Planning Application Ref: CM/21/19/PL

Location: Land adjacent to Scyld, Horsemere Green Lane, Climping, BN17 5QZ

Description of works: Construction of 9no. dwellings, access, landscaping and associated works

Tree Officer / Parks and Greenspace Team

Drawing Title
Tree Retention and Protection Plan
Sheet 01

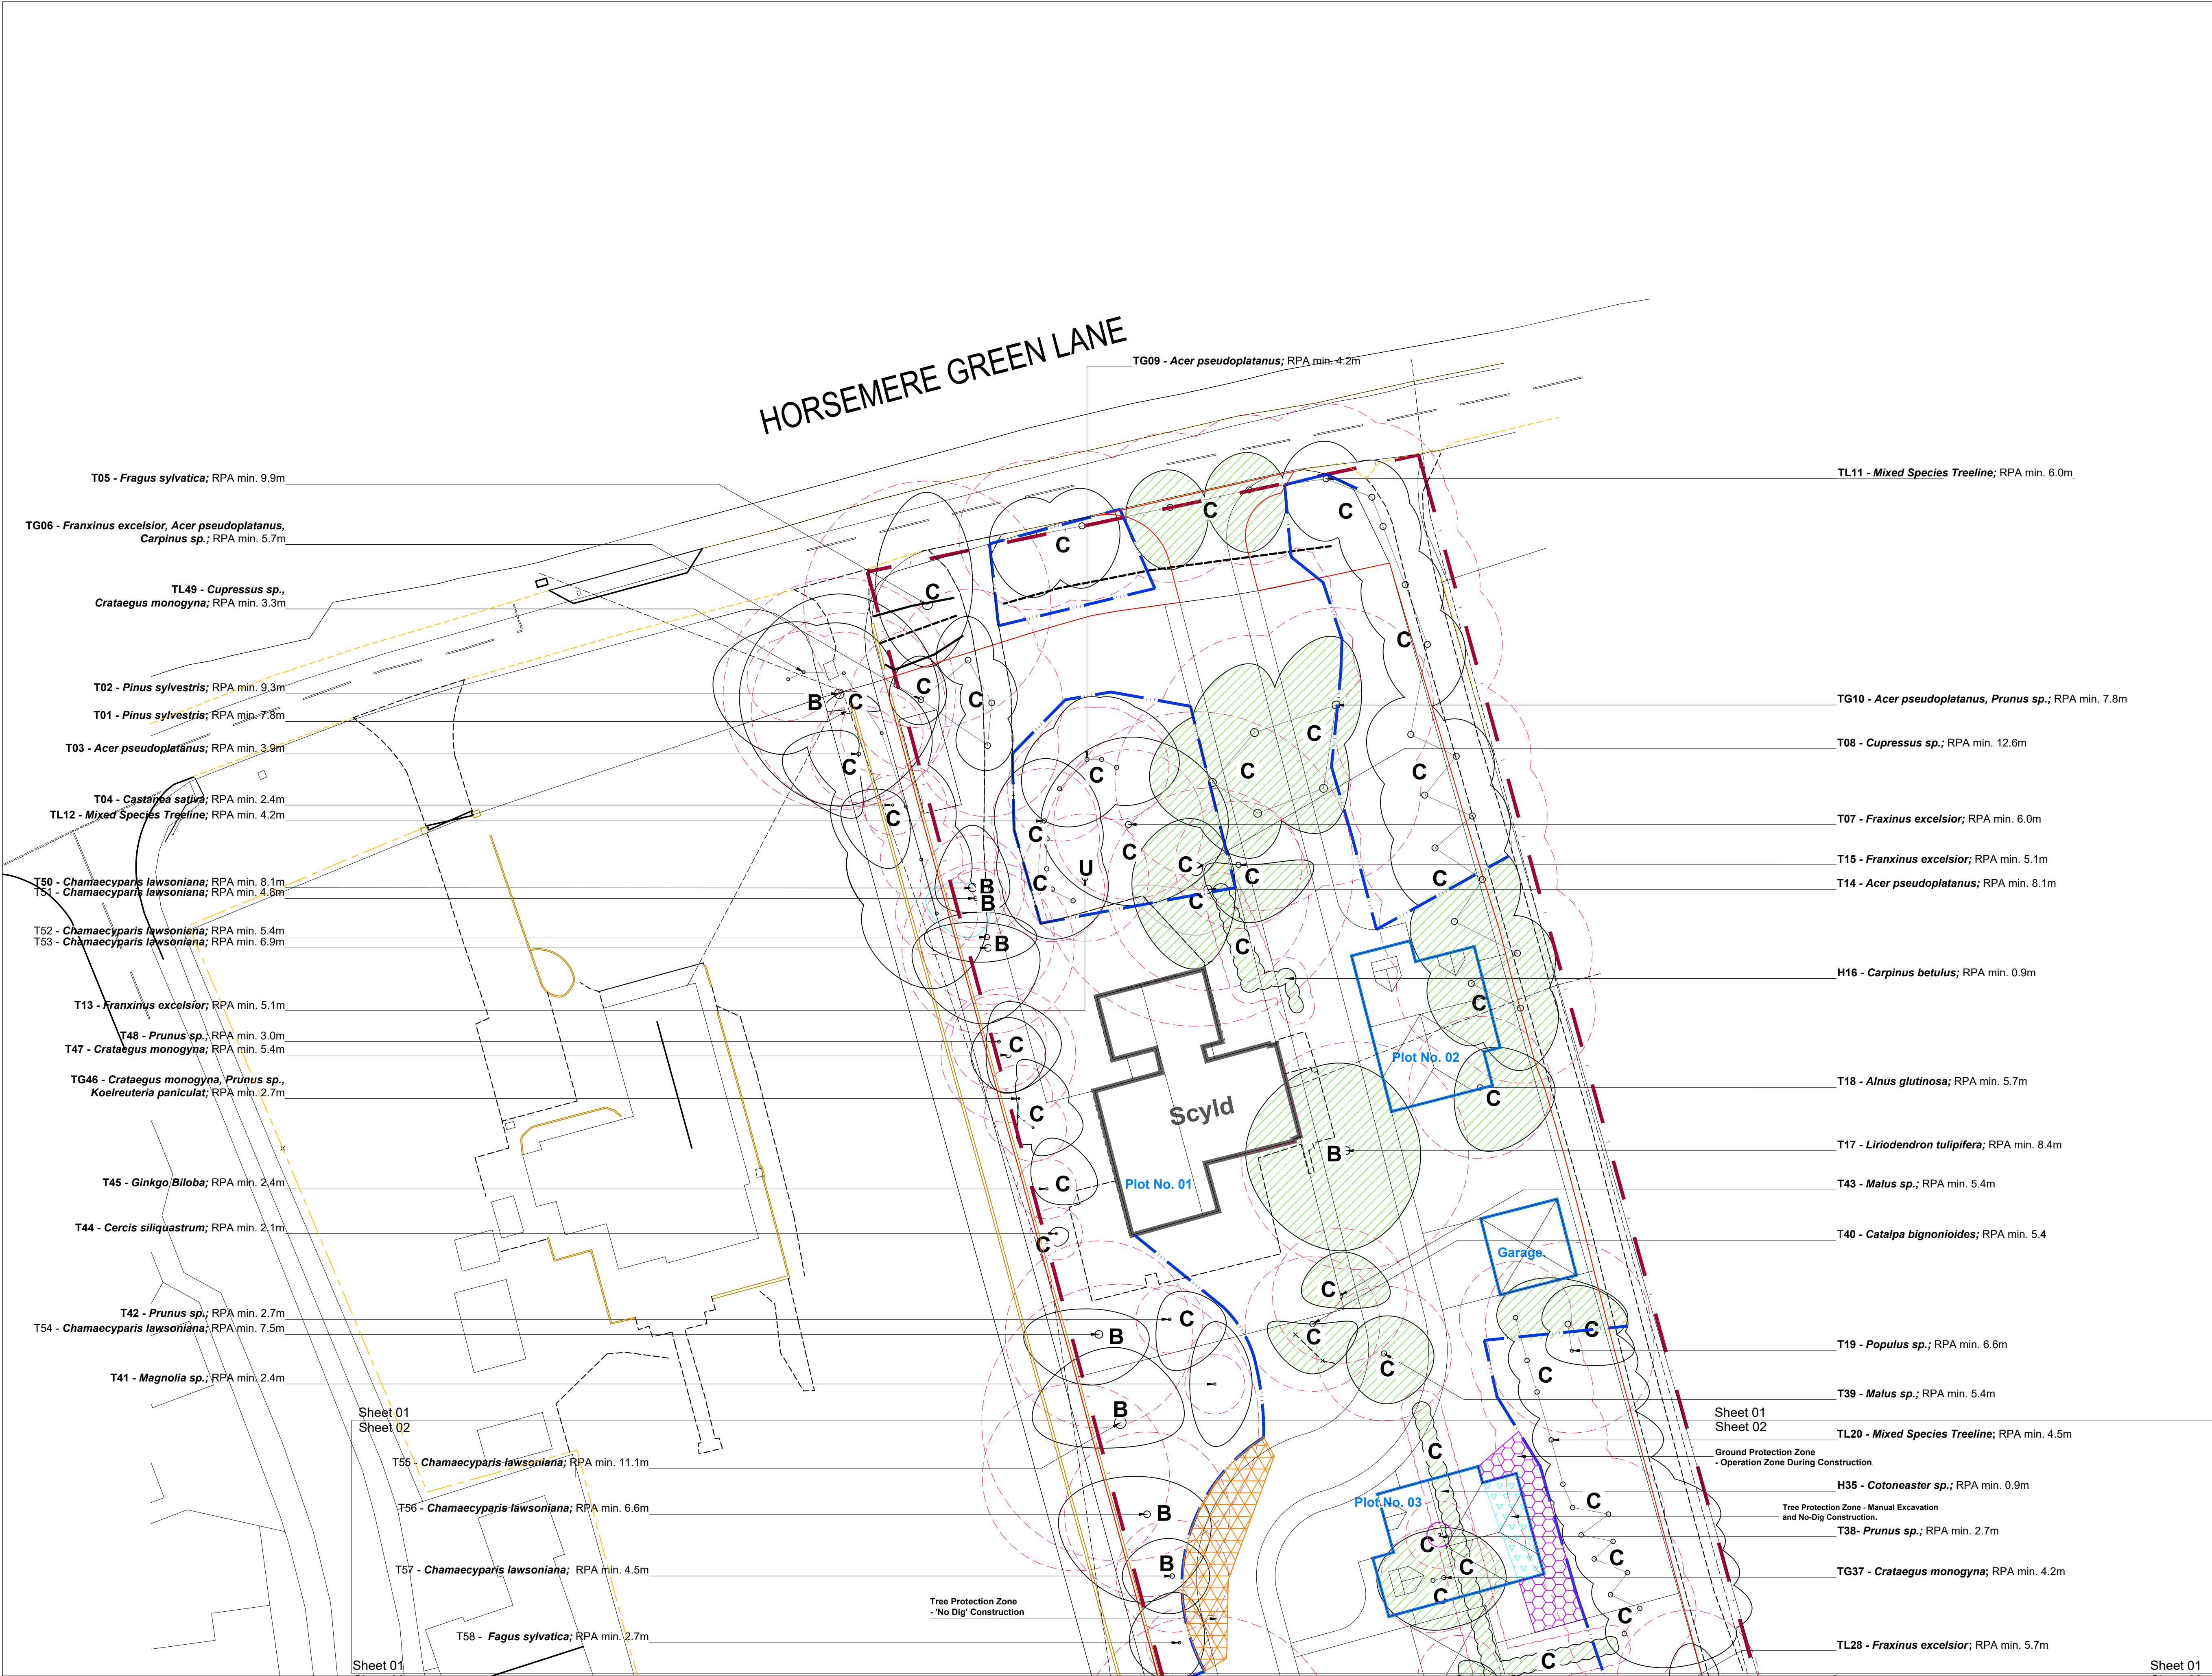
- Before the site is occupied or any machinery is introduced to the site or demolition work or construction work or alterations to existing ground levels takes place a **PRE-COMMENCEMENT Site Meeting** is to take place between the Planning Authority's Tree Officer and the Arboricultural Expert representing the site owner(s) – at this meeting all protective fencing and ground protection measures will be inspected to verify they are 'Fit for Purpose' as required under British Standard 5837:2012 and have been erected and positioned exactly as shown on the **Tree Protection Plans, dwg. nos. LLD1483-ARB-DWG-003 Rev 01 and LLD1488-ARB-DWG-004 Rev 01.**
